Our Ref: WIT/WIT/569138C.1/Carrington Group Mains Lane Limited

1 October 2019

Reference TR010035: A585 Windy Harbour to Skippool Improvement Scheme (the "Scheme")
Objection by Carrington Group Mains Lane Limited ("Carrington")
Reference: WHSK-AFP032

HM Land Registry Current title plan

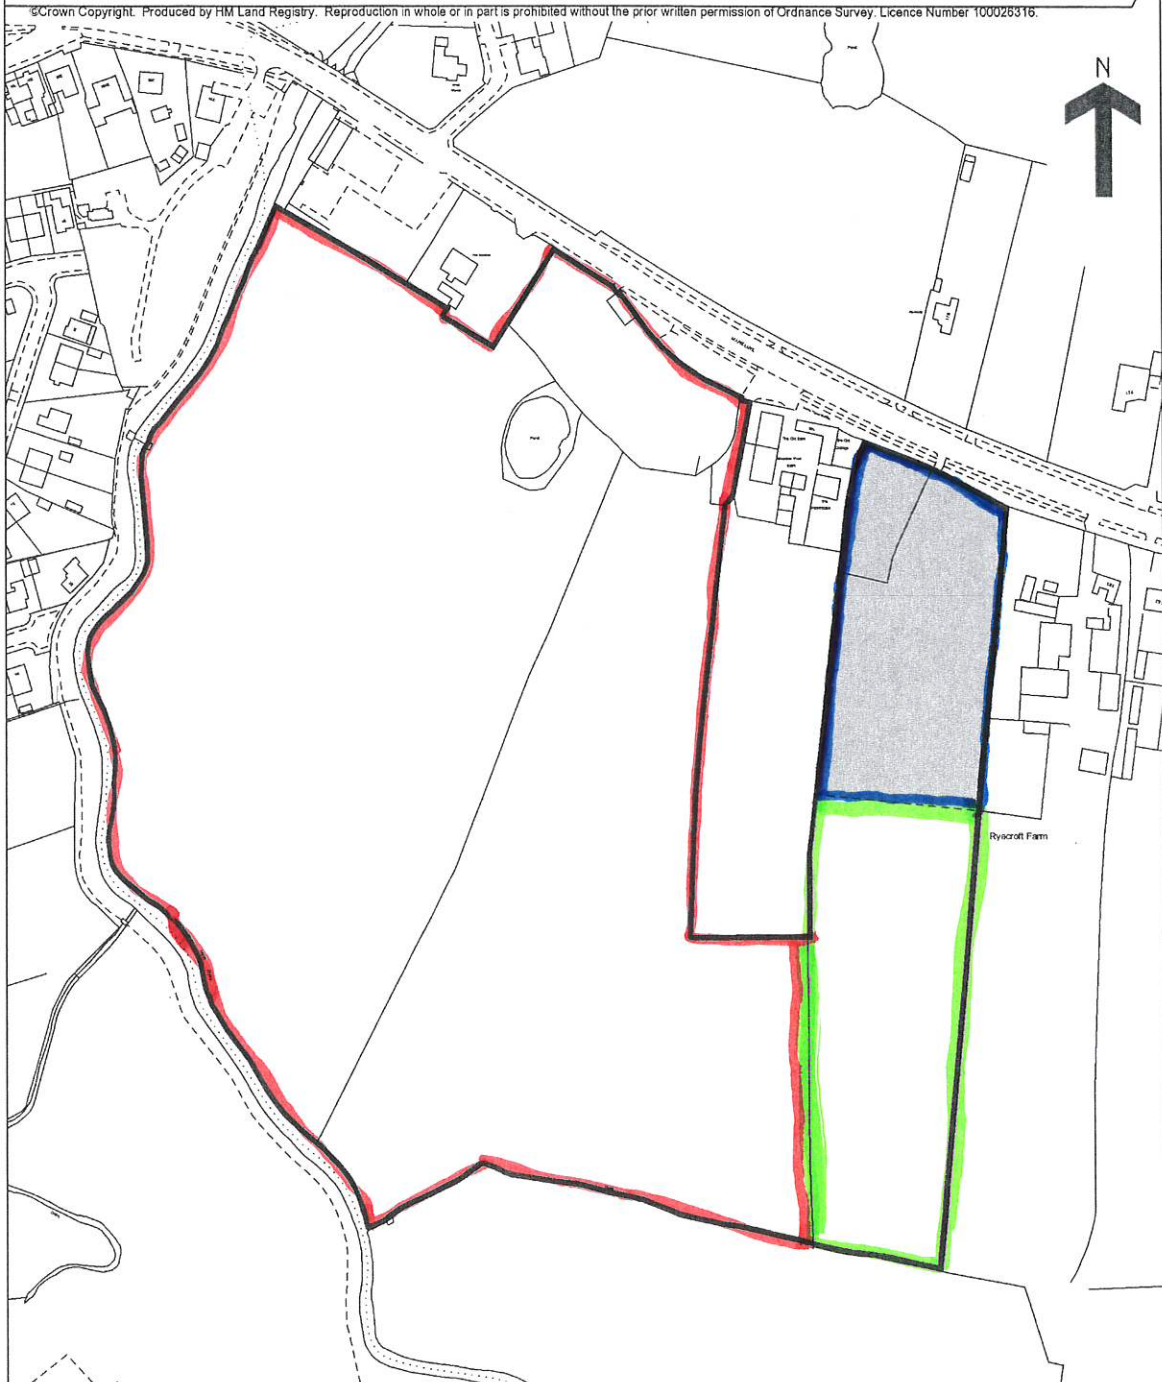
As previously confirmed, Carrington is the registered proprietor of the land shown edged red, blue and green on Plan 1 (the "**Land**"). For the purposes of these representations the land coloured red is "**Parcel 1**", the land coloured blue is "**Parcel 2**" and the land edged green is "**Parcel 3**".

Parcel 3 consists of approximately 5.8 acres immediately to the South of Parcel 2. The route of the new road runs directly through the Parcel 3 and so the Scheme, if implemented, will not only result in the loss of Parcel 3 to Carrington, but will also prevent the proposed development of Parcel 3 by Carrington now or in the future.

Carrington consider that this land could release at least a further further nine residential dwellings and therefore objects to the route of the Scheme and seeks realignment of the route away from the Southern Land so that it can make more efficient and better use of its land while it co-exists with the Scheme.
